From: Finlay Gardner <Finlay.Gardner@arun.gov.uk>
Sent: 19 May 2021 17:48
To: Planning.Responses <Planning.Responses@arun.gov.uk>
Subject: FW: Property 339 Chichester road, Objection

Concerning the property 339 Chichester rd and Mr Delaney's planning application to develop an entrance on the bend at Bedford avenue.

SITE PLAN - SHOWING VISIBILITY SPLAYS
1:500 SCALE (at A3)

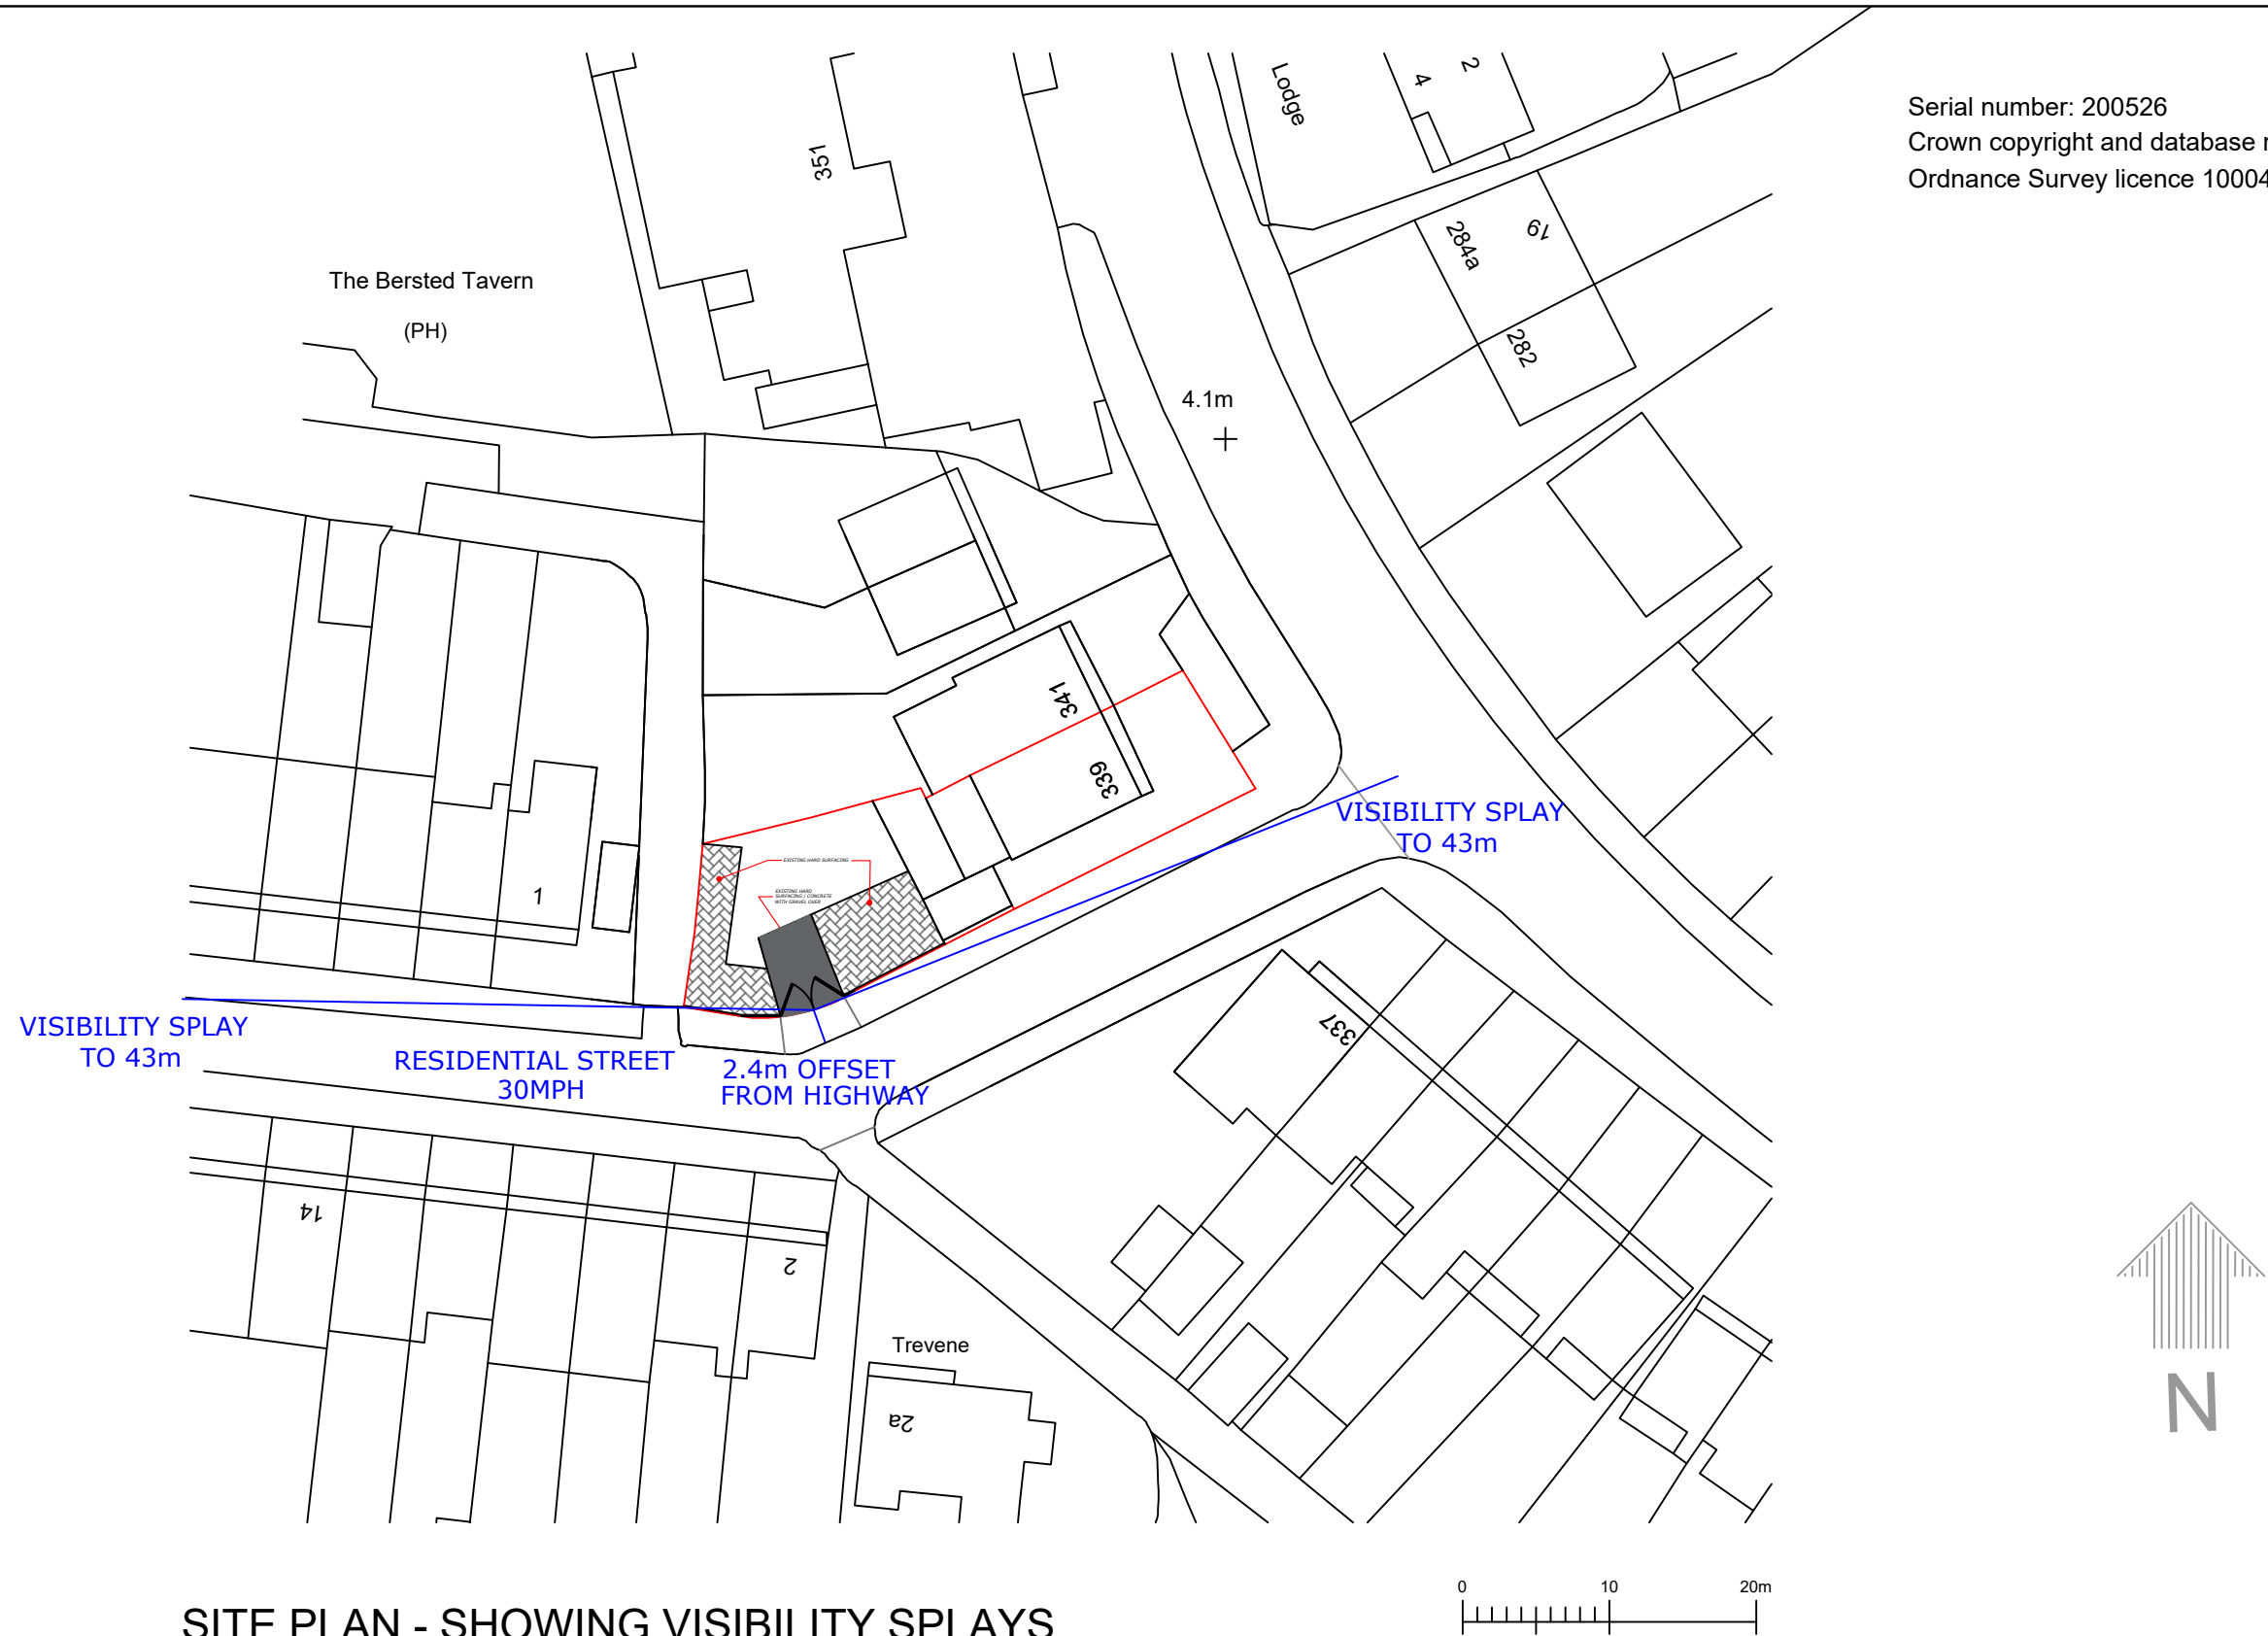
Can you record this as a Public Objection please and also note that I am unhappy (as are many residents) with him installing the drop kerb without planning permission.
